Andrew Beattie - The Issues Associated with the Design of the Proposed Relocation of the Berry Equestrian Centre

The Issues Associated with the Design of the Proposed Relocation of the Berry Equestrian Centre

This submission concerns the impact of the proposed Foxground and Berry Bypass on the Berry Equestrian Centre which is located in North Street Berry.

The Issues Associated with the Design of the Proposed Relocation of the Berry Equestrian Centre

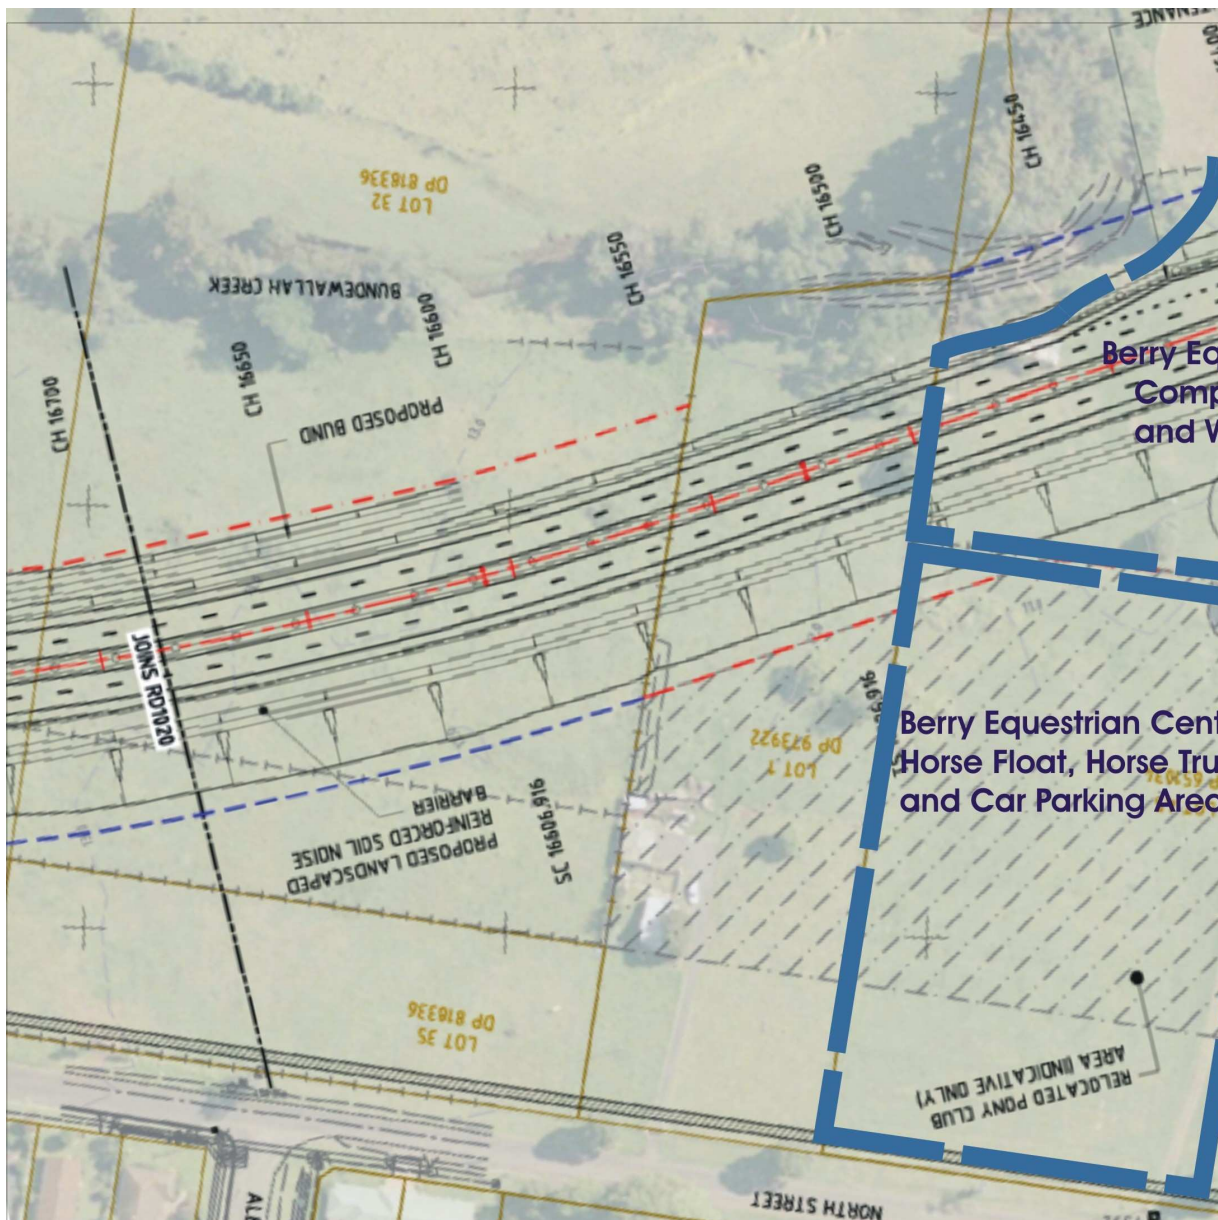
1. The competition grounds are required to be rectangular /square in shape of a minimum size of 140 metres x 140 metres with a level, well drained, good riding surface in order to cater for at least 4 dressage arenas or 2 showjumping arenas.

2. The parking area is required to be of a minimum area equivalent to 90 metres x 160 metres and allow for easy entry, maneuverability, parking and exit of horse floats and trucks. Each parking space is equivalent to an absolute minimum of 4 normal vehicle spaces due to the need for unloading/loading and tie up areas for horses.

3. There is concern for the safety of horses, riders and the general public due to the near location of the proposed riding area to the 4 lane expressway, the skateway, the public cycleway/walkway and North Street. There will be anticipated significantly increased noise and visibility of cars and trucks travelling at 100km/hour on the expressway with horses competing nearby, often with young, very inexperienced riders.

4. Access to the grounds is likely to be across a public shared cycleway/pathway. The safety of children on skateboards, bicycles etc are at risk as horse trucks and floats cross the pathway. Horse floats and trucks also require an indented driveway of at least 15 metres to allow vehicles to park off the roadway whilst gates to the grounds are opened.
